3 October 2011

RE: 330 Church Street, Parramatta: Mixed Use Residential, Retail and Commercial Development. MP 10_0171

DRAWING NAME
ELEVATIONS - PODIUM

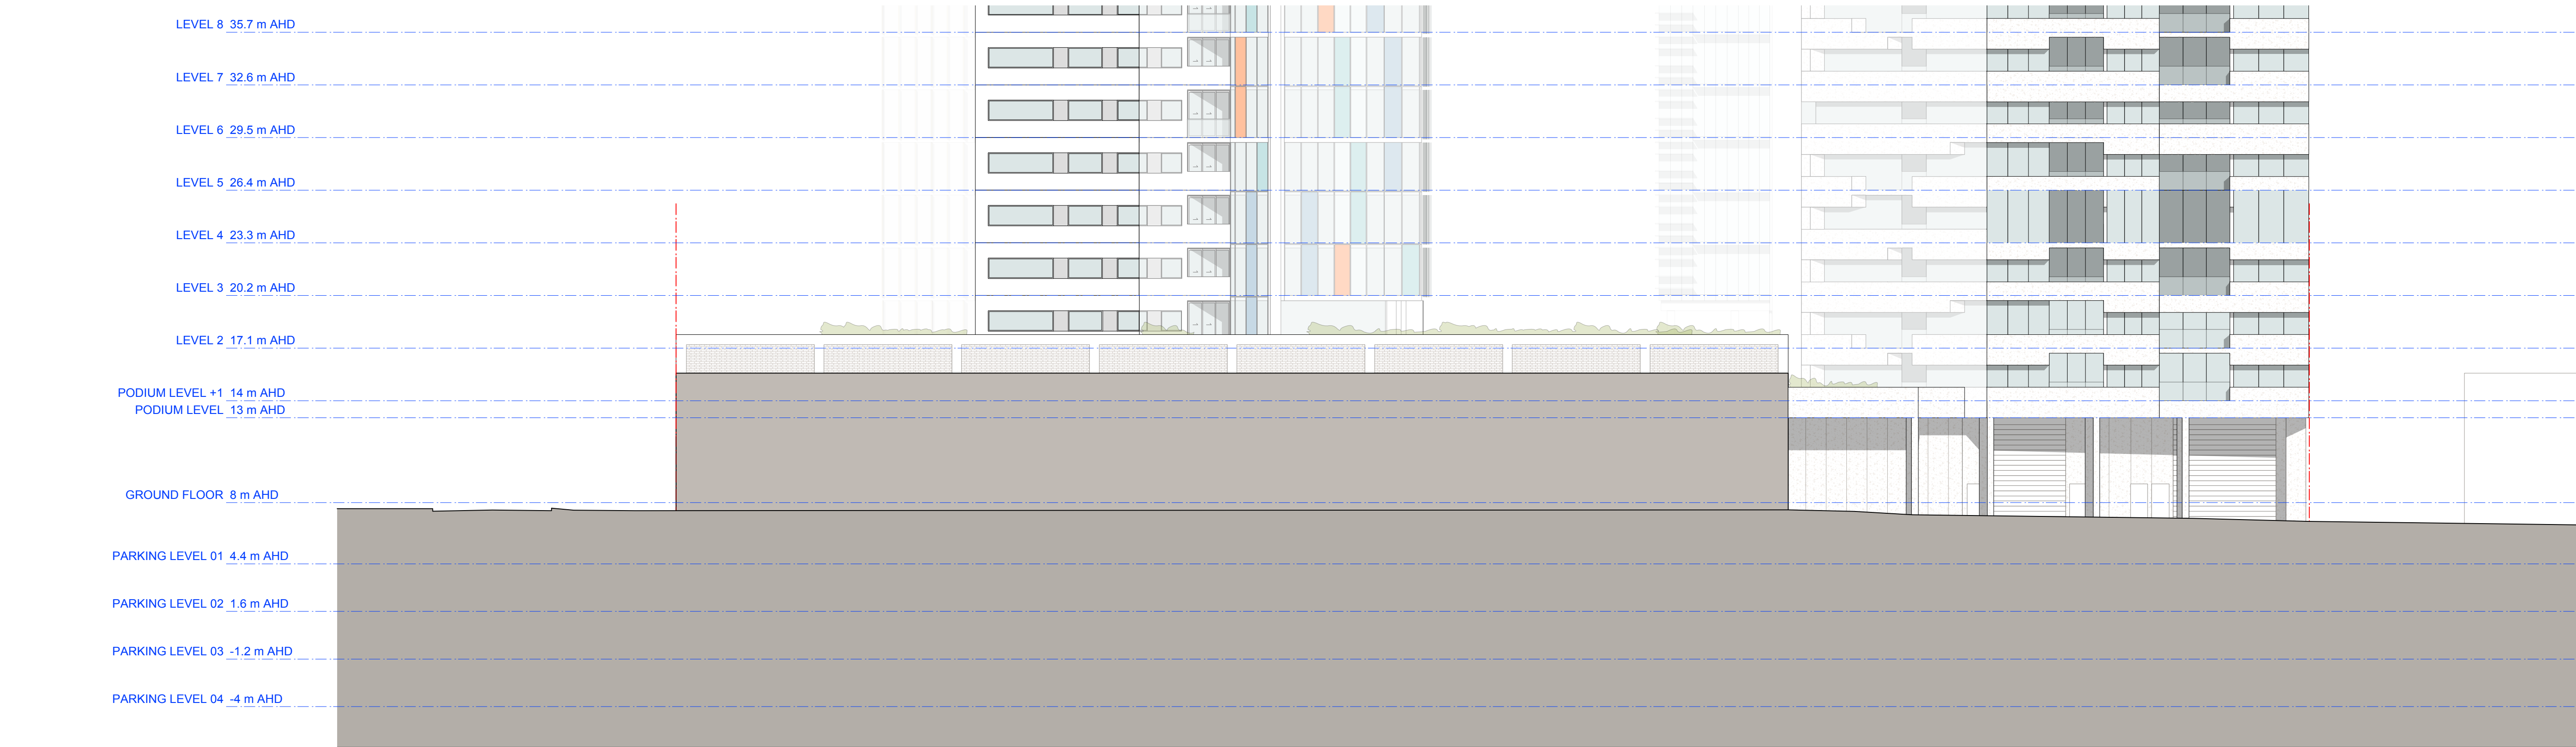
We note there is a non-compliant proposal for two towers, both over the maximum building height of 80 metres, with one tower exceeding the maximum building height by 37.6 metres.

Of particular concern is the impact this development will have on the setting of Old Government House and Domain, Parramatta Park, which is not only of Local and State heritage significance but is included on the National Heritage List and is one of the eleven sites in the Australian Convict Sites World Heritage property. The development will be visually intrusive above the tree line and has the potential to detrimentally impact the setting of Old Government House and Domain, Parramatta Park, and hence negatively affect the place's heritage values. The heritage significance of this important and valuable part of our cultural heritage is linked to the retention of this significant setting.

1. Australia ICOMOS recommends that the Director-General instructs the proponent to refer the proposed development for assessment under the *Environment Protection and Biodiversity Conservation Act 1999* (the EPBC Act).
2. Australia ICOMOS expresses concern about the Statement of Heritage Impact and the Visual Impact Assessment Report and recommends that these documents be revised to properly consider the impacts of the proposed development on the heritage values of this World Heritage Site and National Heritage Listed place.
3. Australia ICOMOS would like to opportunity to comment on the revised Statement of Heritage Impact of these National and World Heritage values, and the revised Visual Impact Assessment Report, once they have been prepared.
